**Re: Buddhist Housing, 308 Wisconsin St NE, Traffic Circulation Layout
Architect's Stamp dated 3-5-14 (K19D147)**

Based upon the information provided in your submittal received 3-6-14, the above referenced plan cannot be approved for Building Permit until the following comments are addressed:

TCL
03-05-14

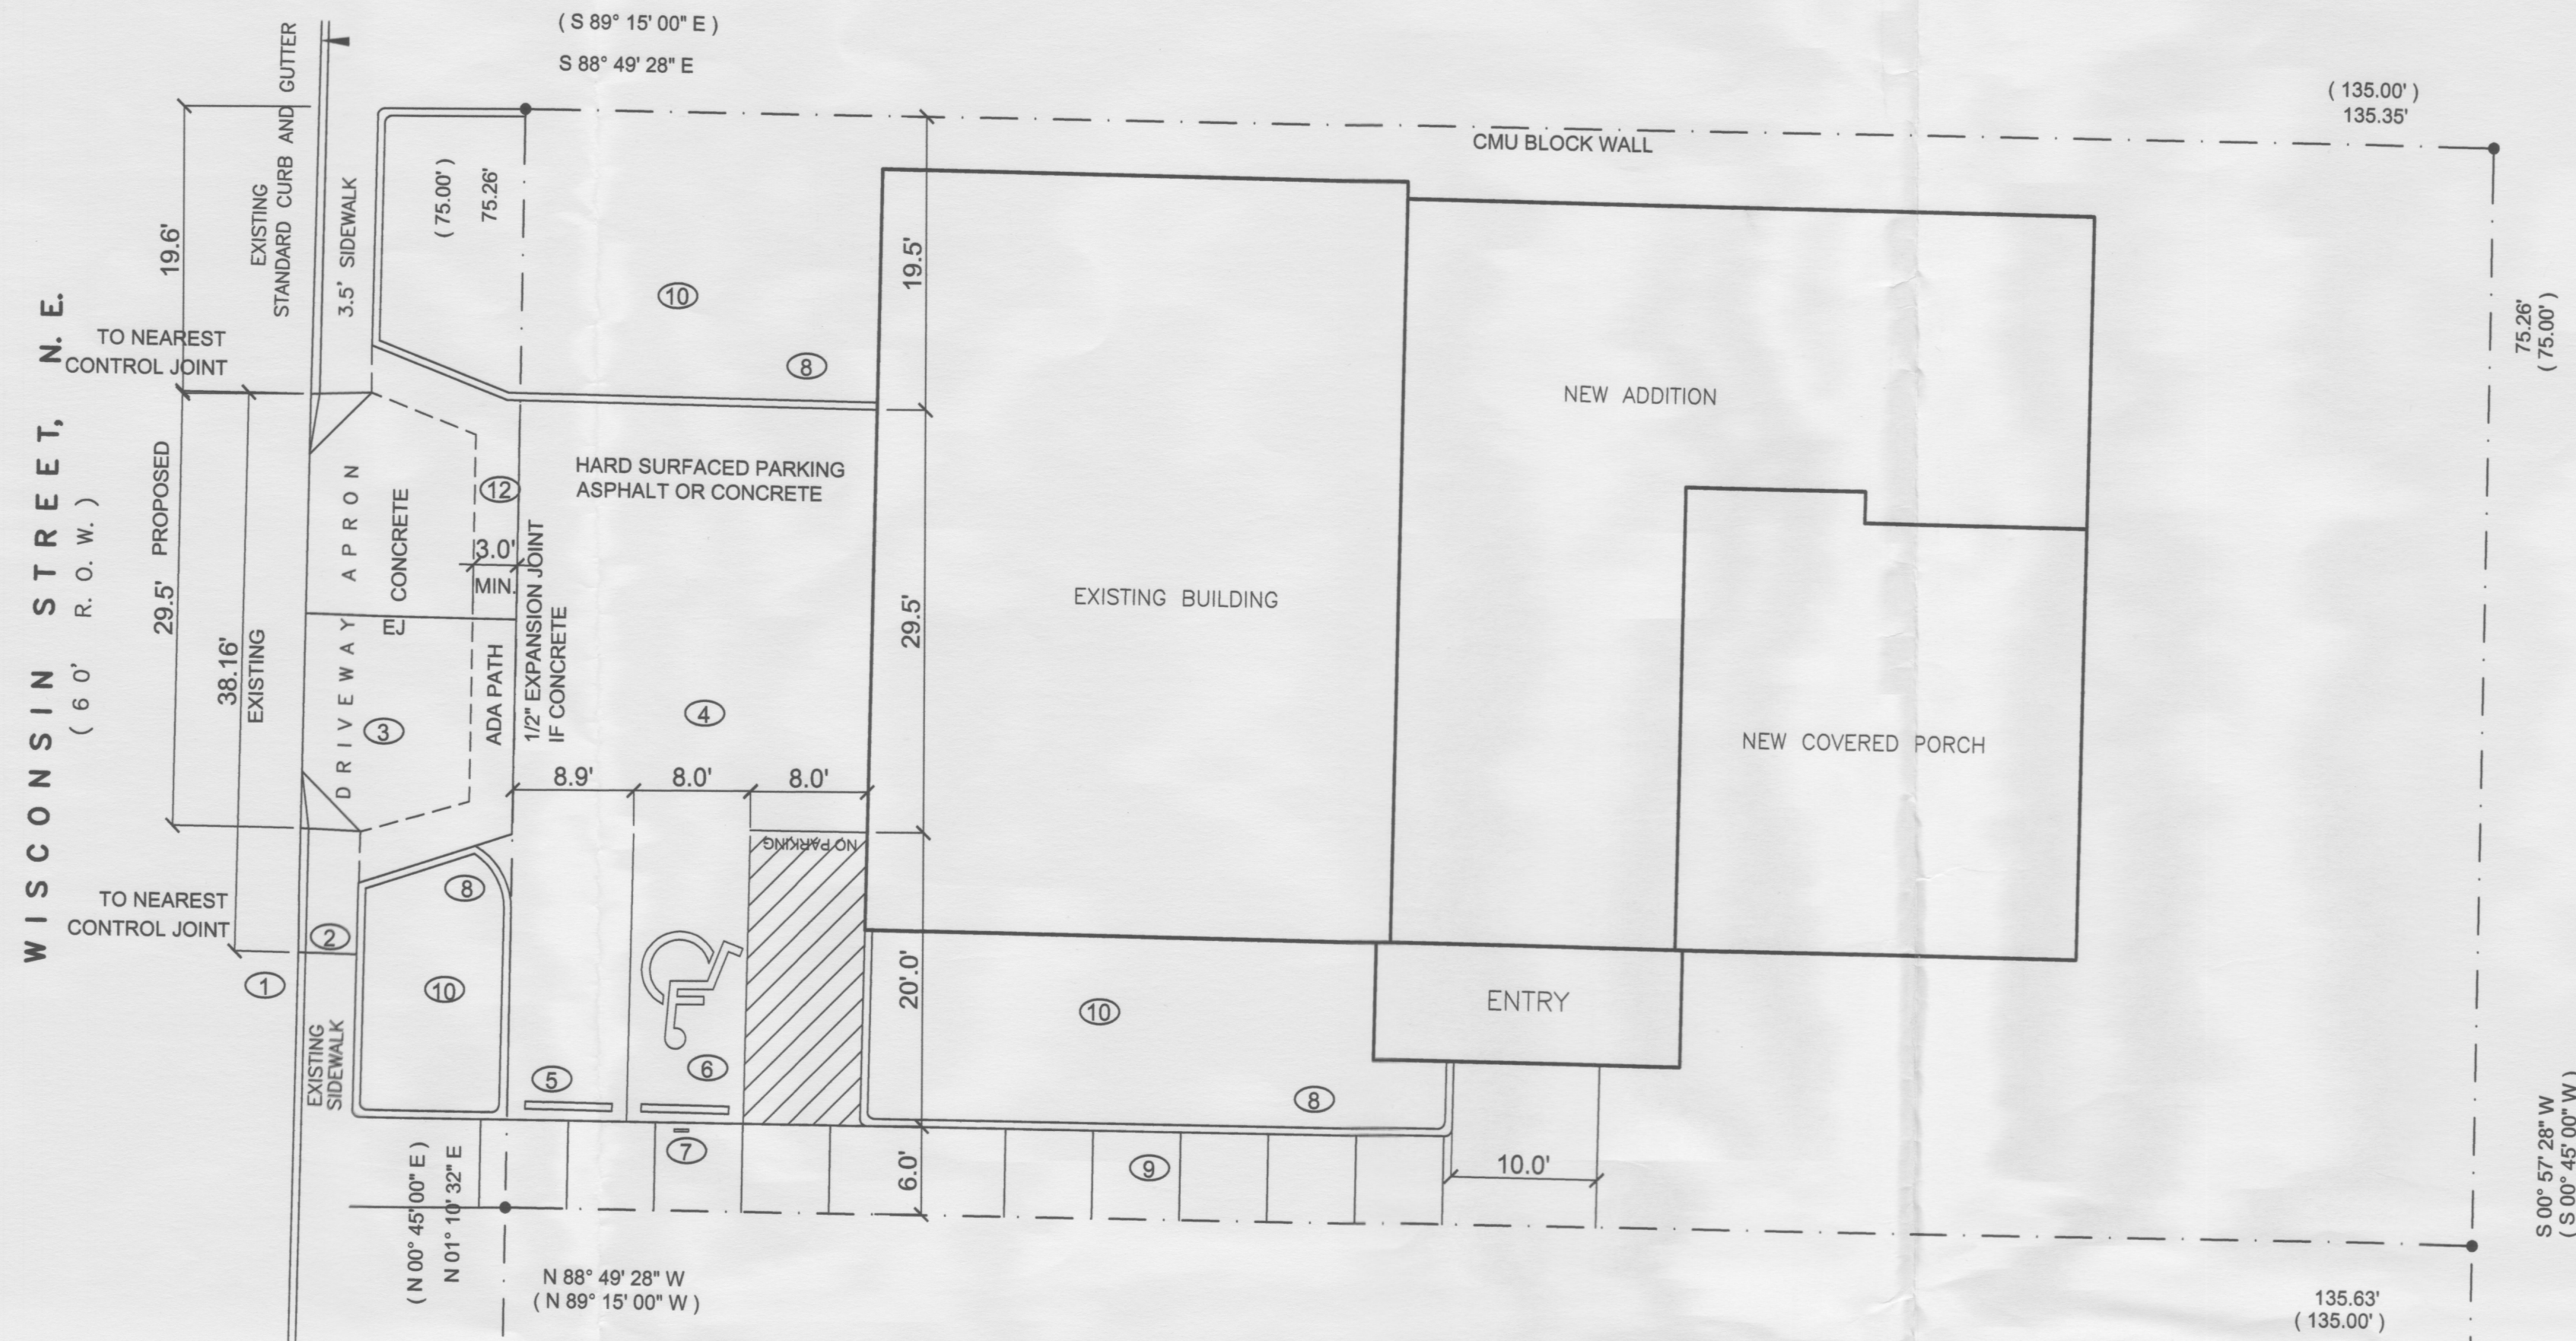
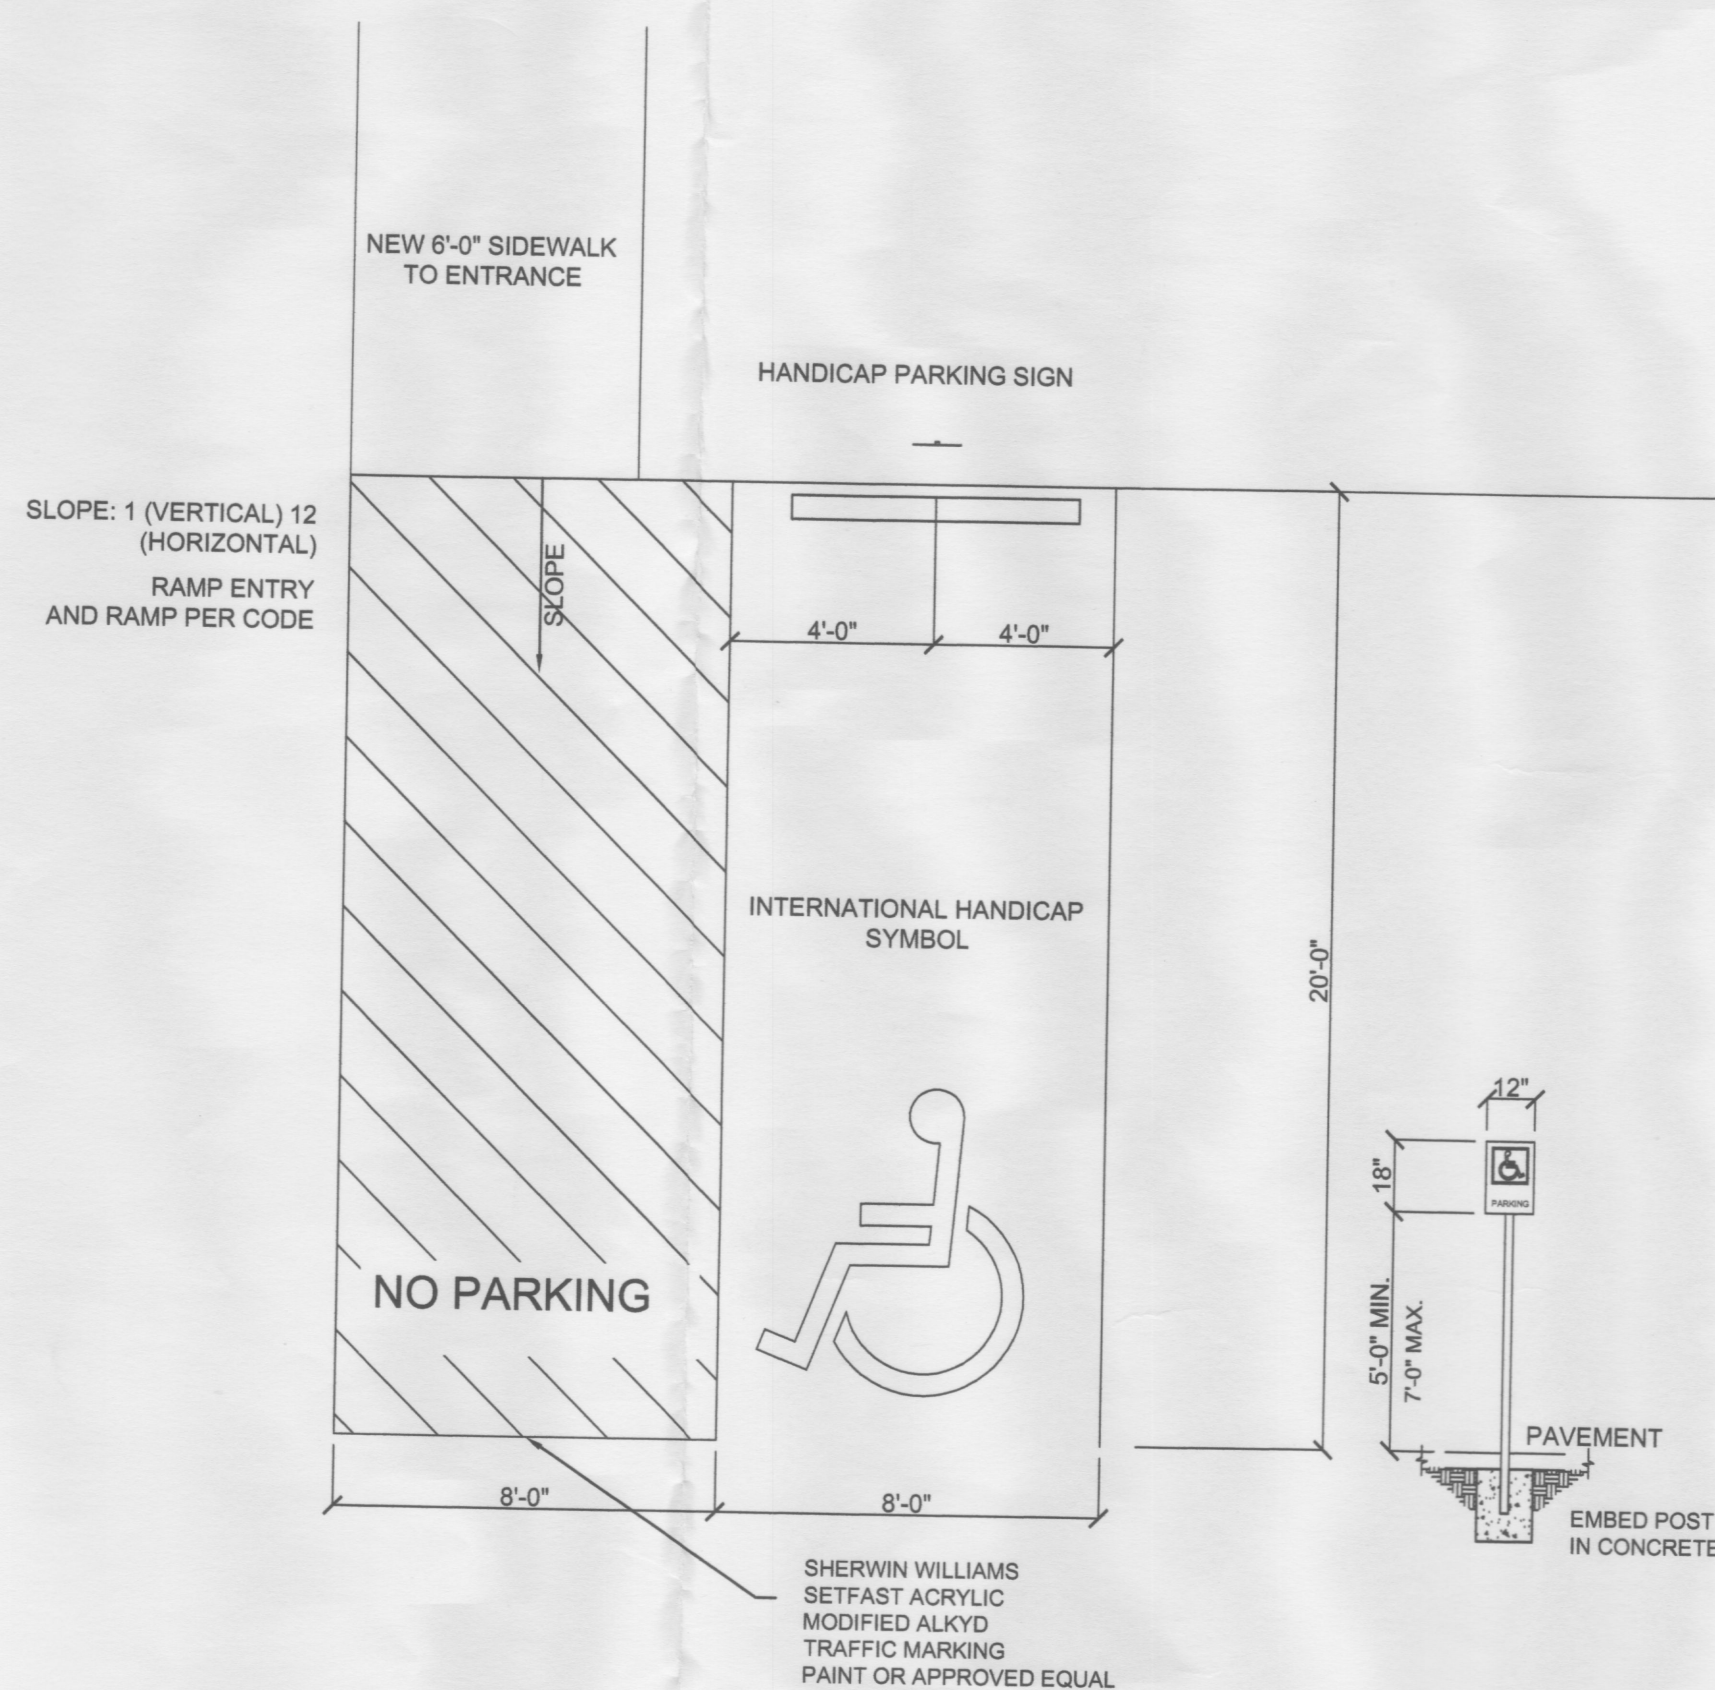
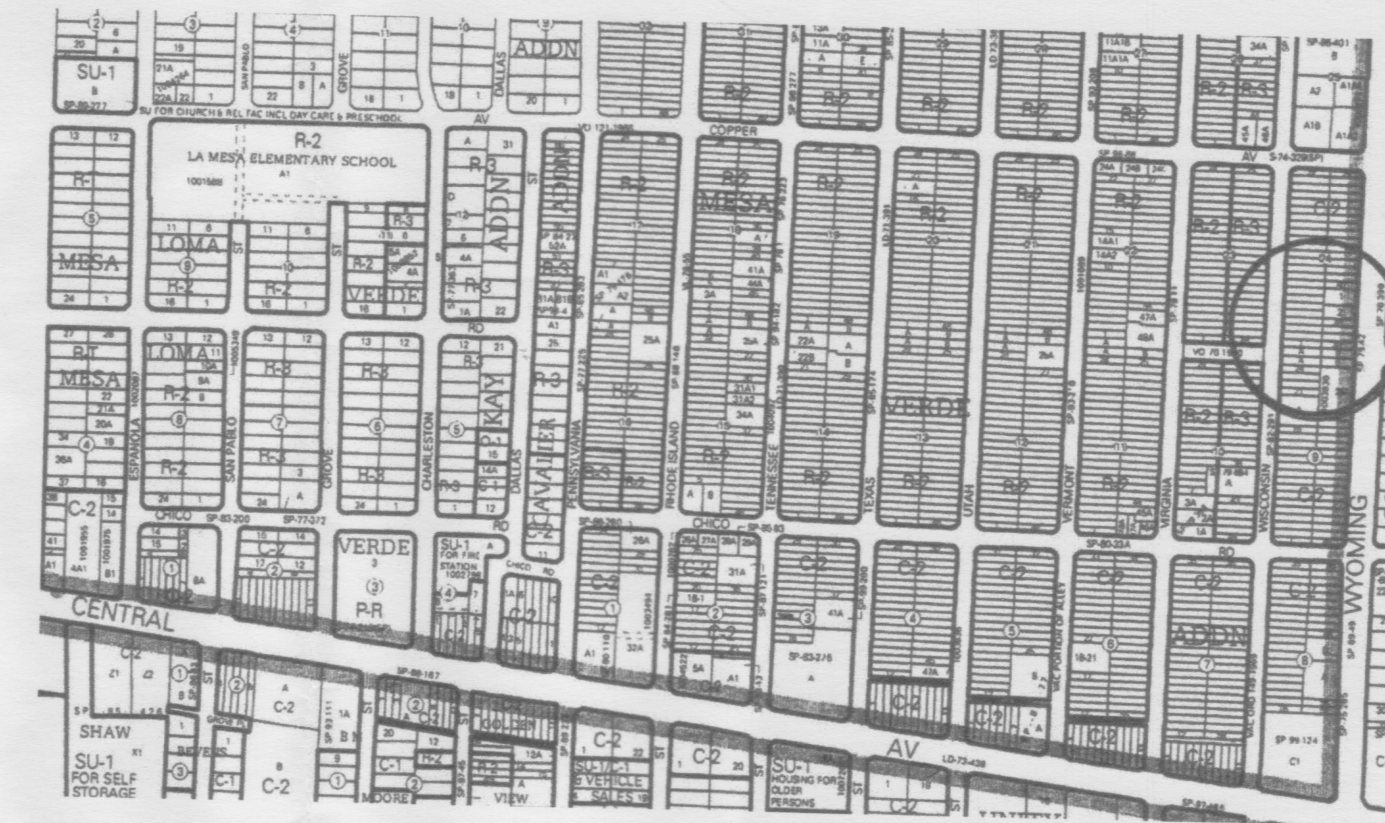
1. The development of this site must be in compliance with current DPM and ADA standards and regulations.
2. Proposed parking can not cross into COA ROW.

3. Proposed parking requires backing into the street. Commercial zones require vehicle circulation to be contained within the site, no backing out into the public street.

4. Please clarify parking required by zoning and parking provided. It appears that zoning requires 2 parking spaces (1 HC w/ access aisle) and the TCL is proposing a total of 3 spaces.

5. Perhaps the front property could accommodate the HC stall and aisle oriented parallel to the street and the other required space could be on the street. To request on-street parking, 50% of the required parking must be off-street.

6. On-Street parking Allowance to fulfill zoning's parking requirement must be requested and approved by the Traffic Engineer, Kristal Metro prior to TCL approval. The application requires 15 working days. On-street parking allowances are based on available parking along public right-of-ways fronting the property. The business will only be granted 50% of available street parking.

7. It is not apparent what type of pavement surface is being proposed. A hard driving surface will be required as part of this proposed project for parking area and drive aisles.

8. Is landscaping required by zoning? If so, please provide landscaping plan with next submittal. Per the *Development Process Manual*, Chapter 23,

Section 7, Part B.6, curbing should be used to separate landscaping from parking areas and pedestrian ways as well as providing a physical perimeter for harvesting water. This must be clearly shown on the TCL.

9. Please add the following note: "Landscaping and signing will not interfere with clear sight requirements. Therefore, signs, walls, trees, and shrubbery between 3 and 8 feet tall (as measured from the gutter pan) will not be acceptable in this area."
